Please ask for: Sian Eggington
Email: sian.eggington@terraquest.co.uk
Telephone: 0121 2341390
Our Ref: LU/282/20/HH
Your Ref:
Date: 15th October 2020

Application for Planning Permission for Works or Extension to a Dwelling

Development: Front access ramp to provide disabled access to front entrance
Location: 78 Southfields Road Littlehampton BN17 6PB

Plan Produced for: Amber Living
Date Produced: 07 Oct 2020
Plan Reference Number: TQRQM20281154326068
Scale: 1:500 @ A4

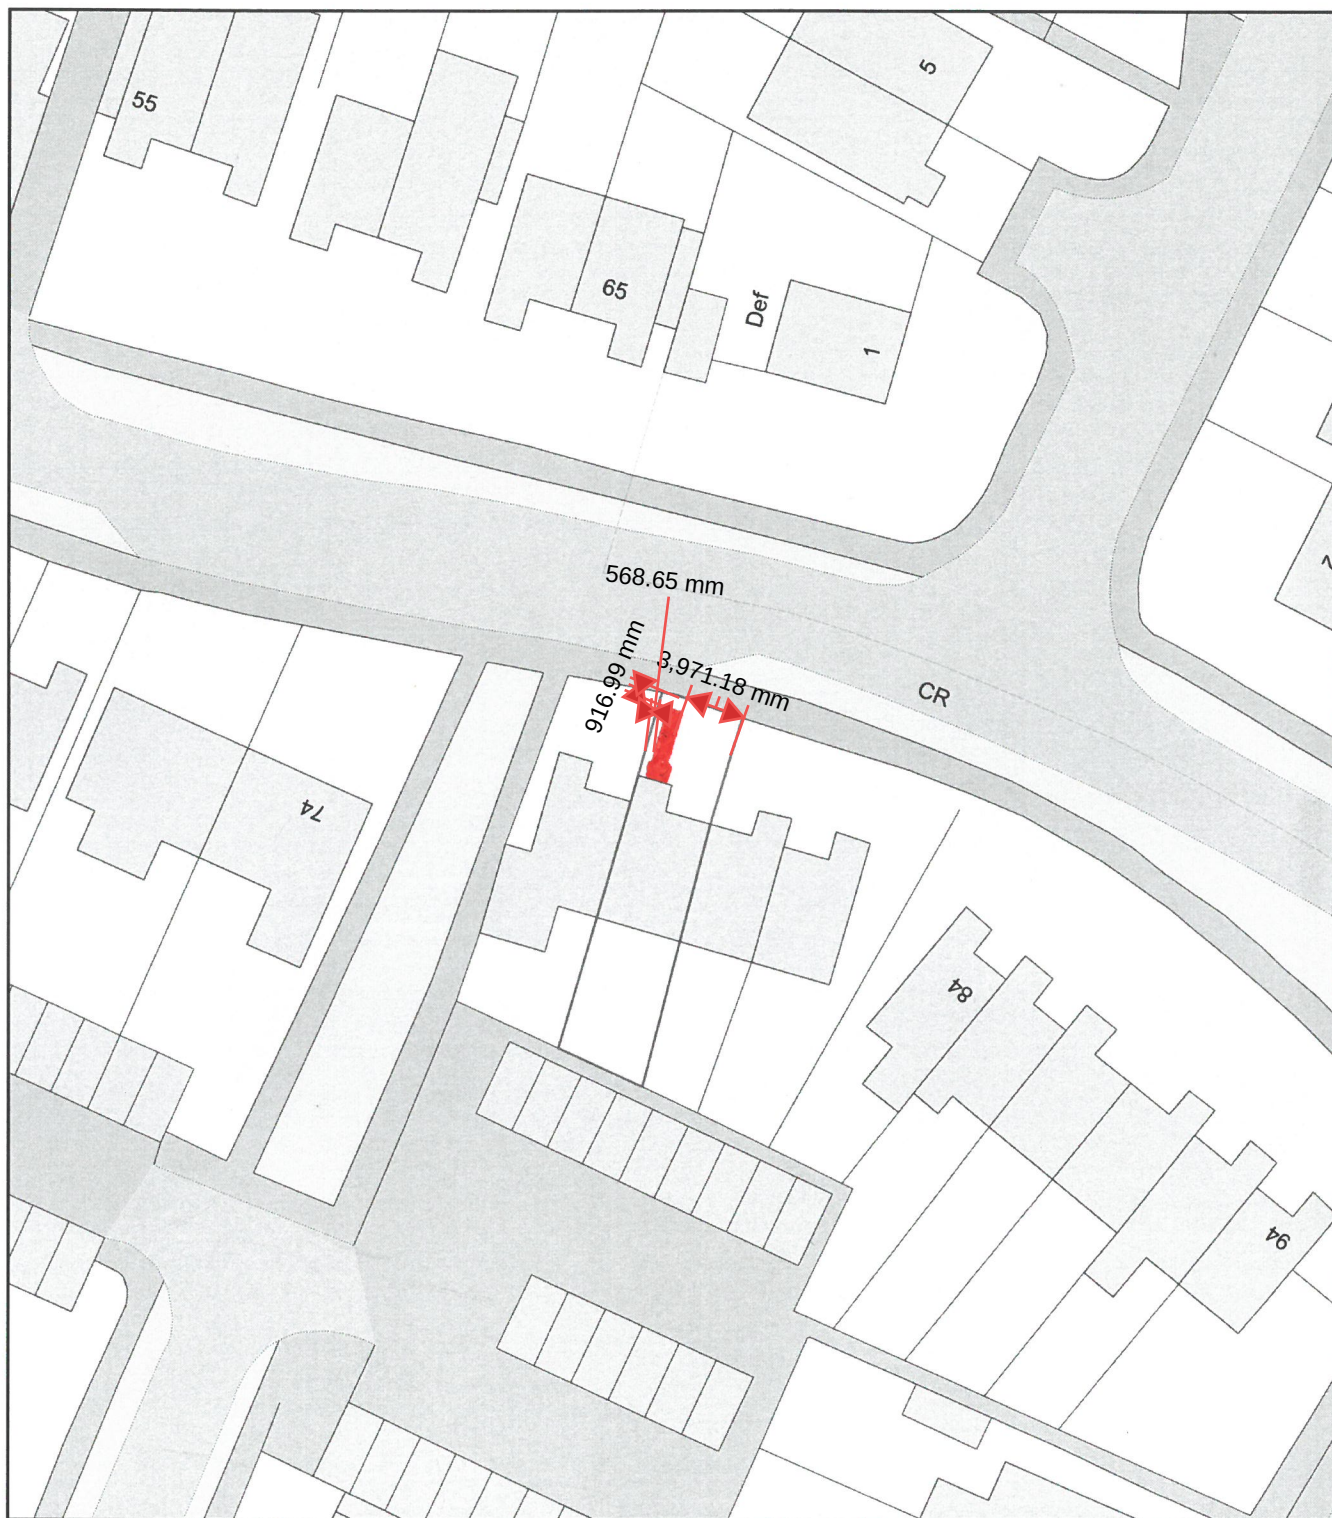
Dimensions: You are required to include dimension on the block plan from the proposal to all site boundaries.
